Ann Machado - Re: Fwd: Fw: Revised Plan

From: Barbara Barhydt
To: Machado, Ann
Date: 5/15/2014 8:48 AM
Subject: Re: Fwd: Fw: Revised Plan

The proposed plan to expand the garage to 24 feet wide, except for the rear corner meets does not further impact the shoreland zone setback as shown on the plan. Thus the Planning Board approval for the extension into the shoreland remains valid. I recommend two conditions of approval:

SITE PLAN
 AT
 6 SAMUEL ROAD, PORTLAND, MAINE
 MADE FOR
ANTHONY NAPOLITANO
 56 BERNARD ROAD, PORTLAND, MAINE 04103

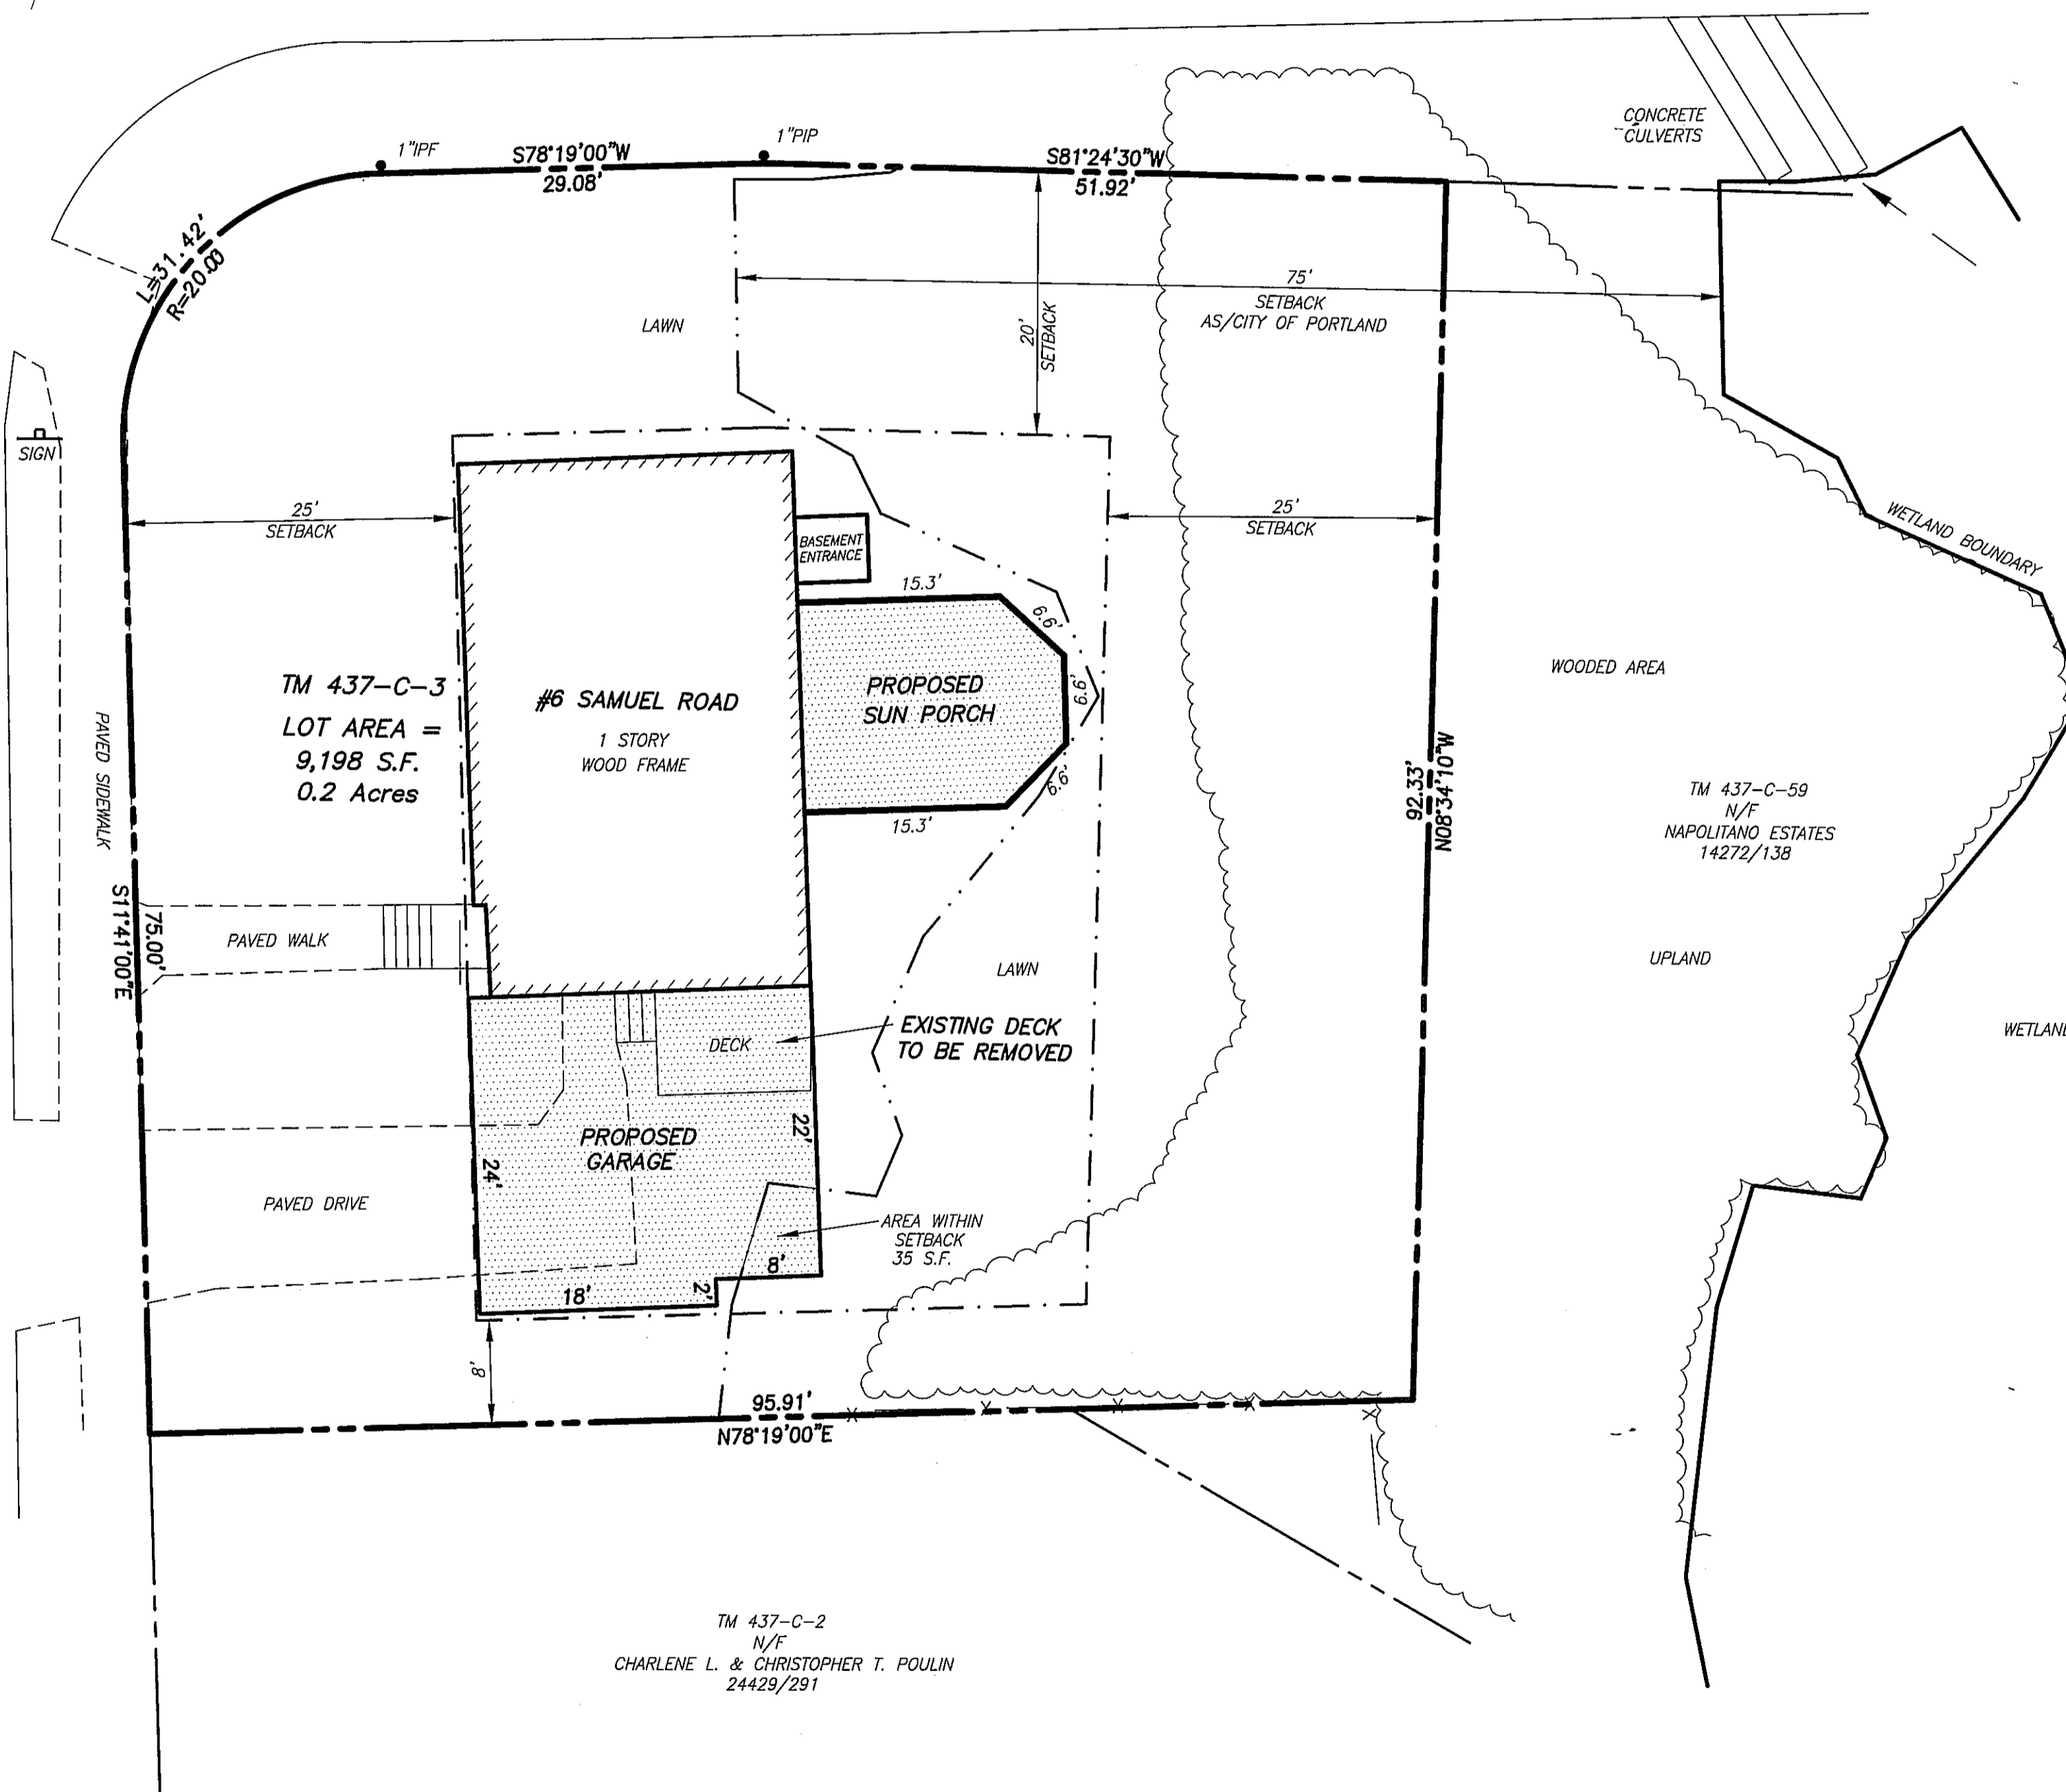
Are you OK with the footprint of the garage being expanded outside of the wetland as shown on the attached site plan?

1. That prior to pouring a foundation, the footprint as shown on the plan be staked out for inspection by the code officer.
2. That a critical note be put on the lot that the garage cannot be expanded without further shoreland zone review.
